Please ask for: Nicola Moore
Email: nicola.moore@arun.gov.uk
Telephone: Ext 37944
Our Ref: FG/46/21/PL
Your Ref:
Date: 24th March 2021

Application for Planning Permission

Development: Development of 1 2 bed house set over 2 floors, with first floor being partially contained within roof, along with associated parking & amenity spaces. This site is within CIL Zone 4 and is CIL liable as new dwelling.

Location: Land Between 11a The Grove And 30 Brook Lane Ferring

Drawing Title 028_04 Proposed Roof Plan Land between 11A The Grove and 30 Brook Lane, Ferring					
Completion date 17/03/2021					
Drawn by Guy Rochez ARB					
Scale: 1:100@A3					
Print Size: A3					
Notes:

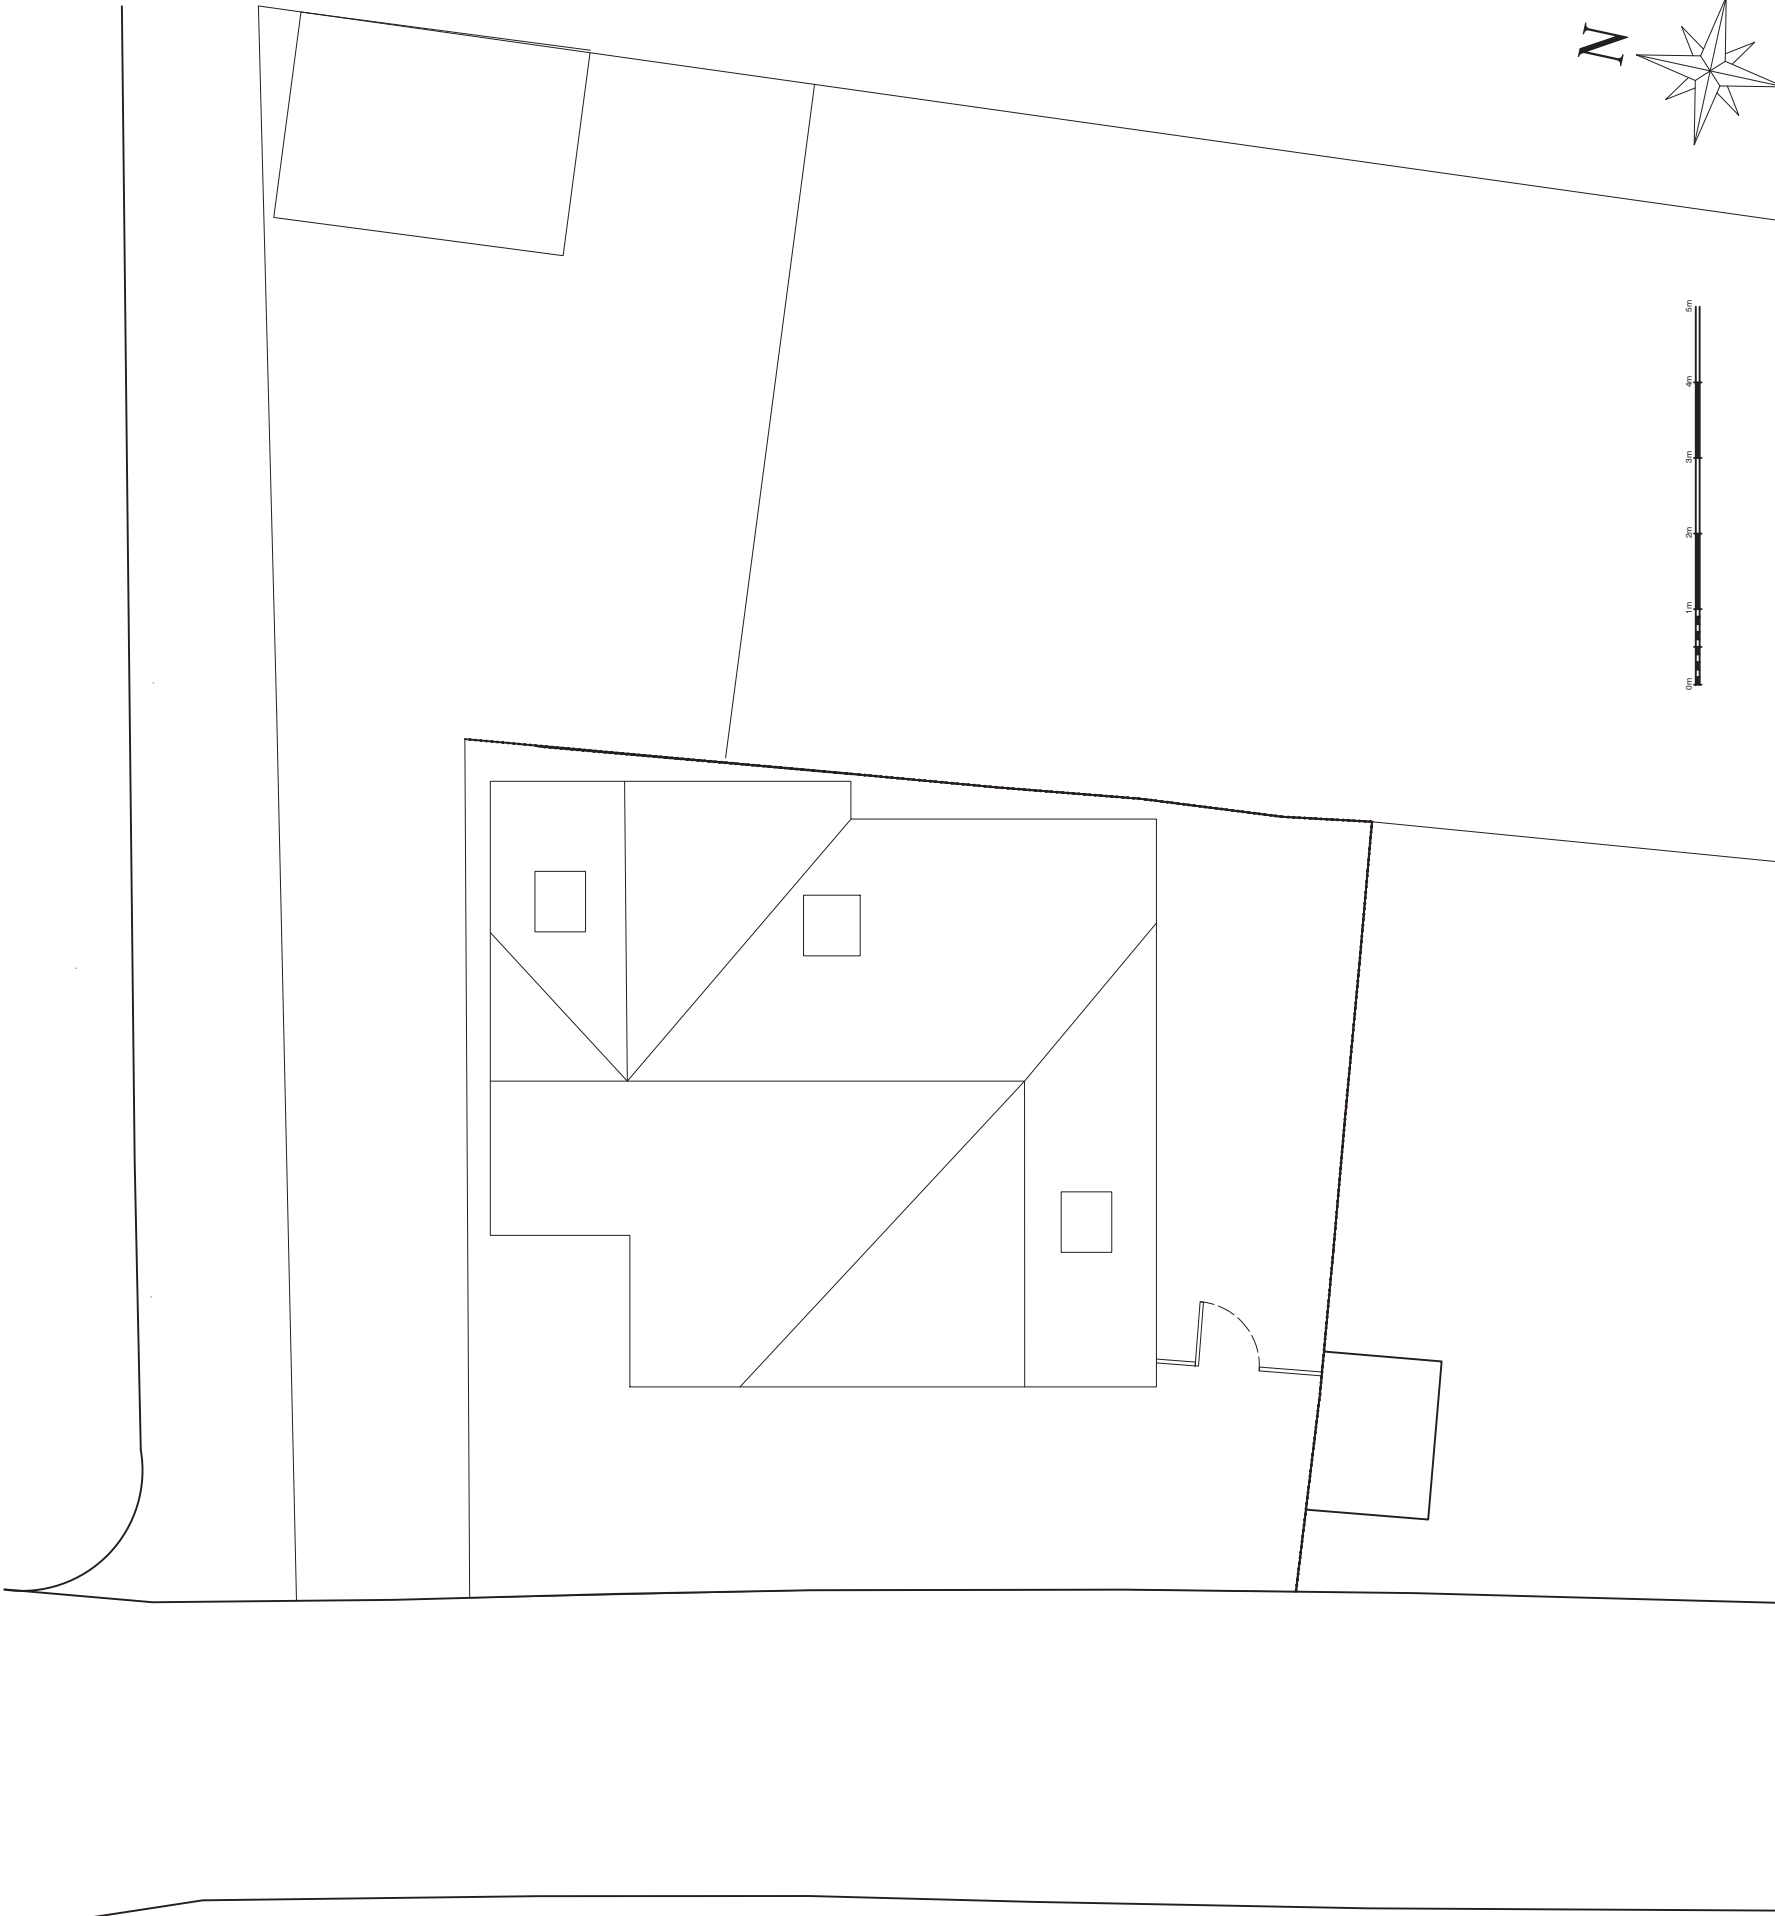
The submitted Roof Plan shows 3 roof lights, however on the Proposed First Floor Plan there are only 2. Please amend plan/s accordingly and re submit.
